**Application: SSI 7485**

We write regarding the Westconnex M4-M5 Link Rozelle Interchange – Modification: The Crescent overpass and active transport links (August 2019).

Figure 4-2 Pedestrian and cyclist bridge infrastructure options

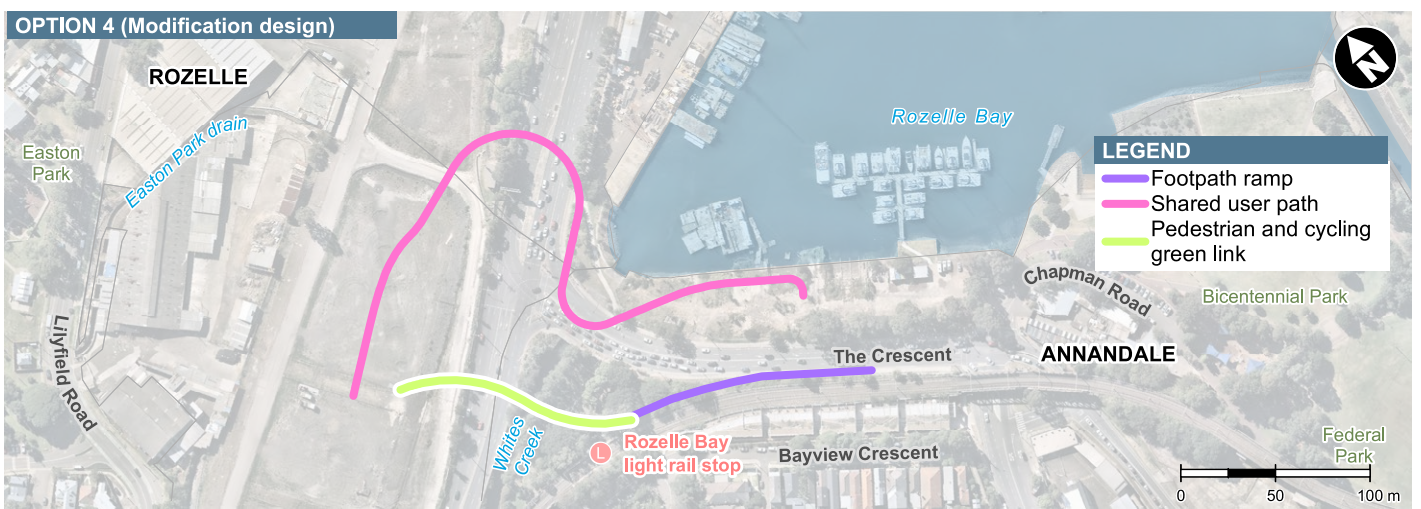
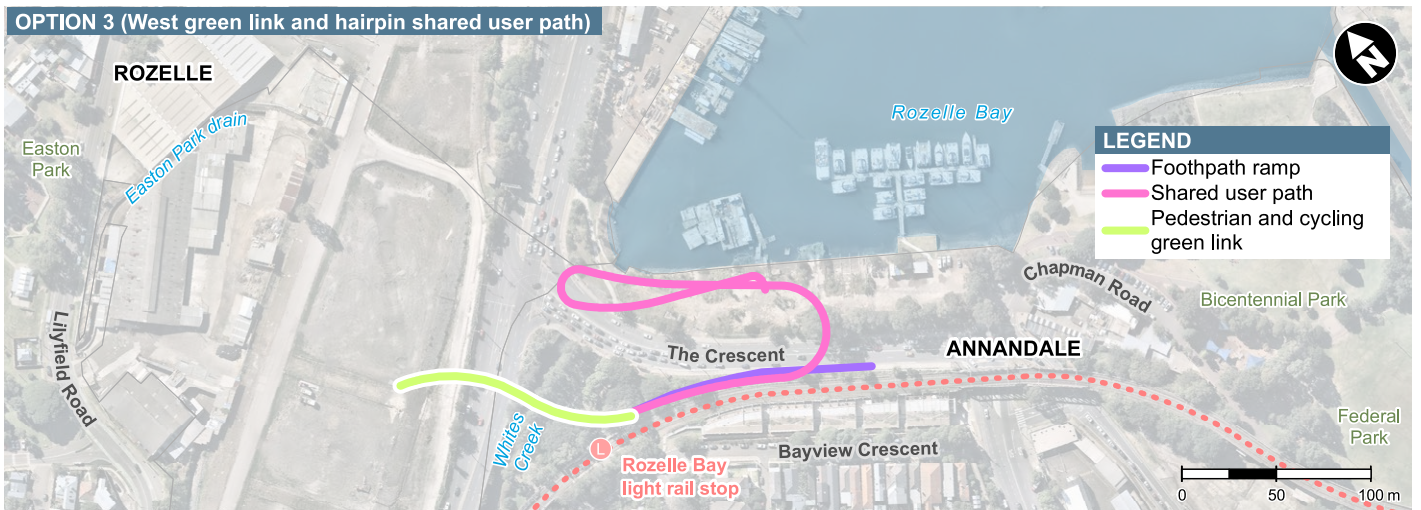
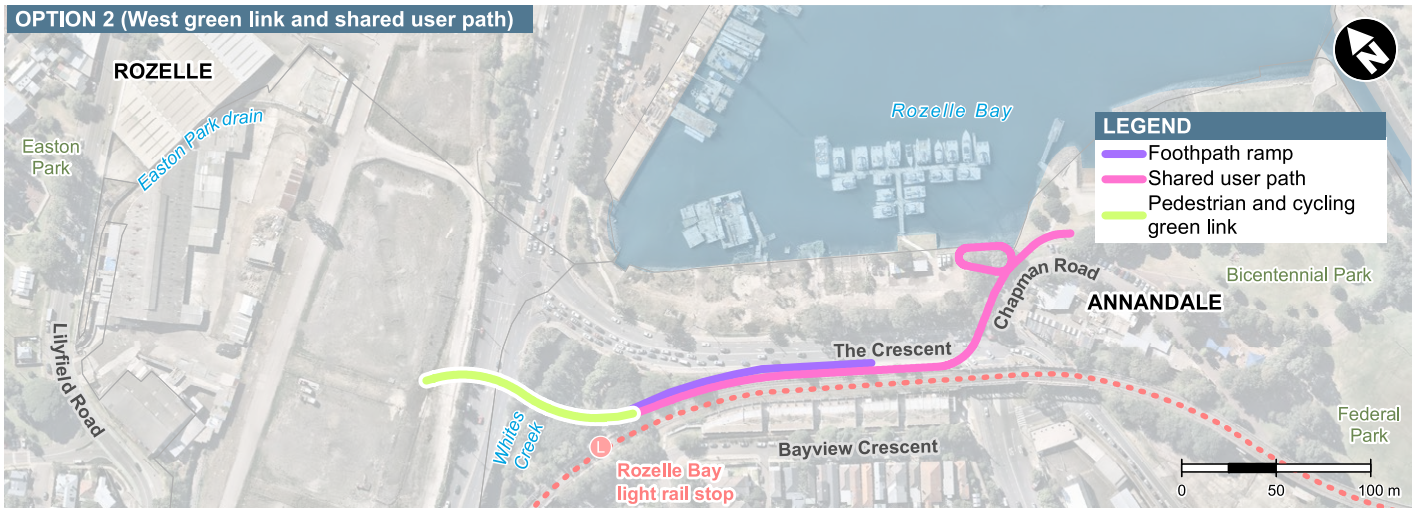
- Reduced safety and increased risk for pedestrians and cyclists coming from Annandale and further west as a result of removal of direct access over The Crescent to Bicentennial Park via the GreenLink.
- Both at-grade level crossing options between Annandale/Lilyfield and Bicentennial Park and the foreshore – The Crescent/Johnston Street/Chapman Road and The Crescent North/The Crescent East – place pedestrians and cyclists in areas of high-volume traffic and involve a crossing with up to five sets of pedestrian lights.
- Removal of direct active links to the foreshore, divorcing the Annandale/Lilyfield community from this area and the proposed revitalisation of the entire Bays Precinct, including linking the Light Rail and Bus stops to a Ferry wharf and Metro station.

We seek the reinstatement of the safe, direct access from the approved EIS GreenLink to create a continuous green open space connection from the Rozelle Rail yards and Annandale/Lilyfield to the foreshore. The GreenLink was more than just a walkway – it put people central to the design, maximising safety, and providing much needed accessible open space for the community now and into the future Bays Precinct design.
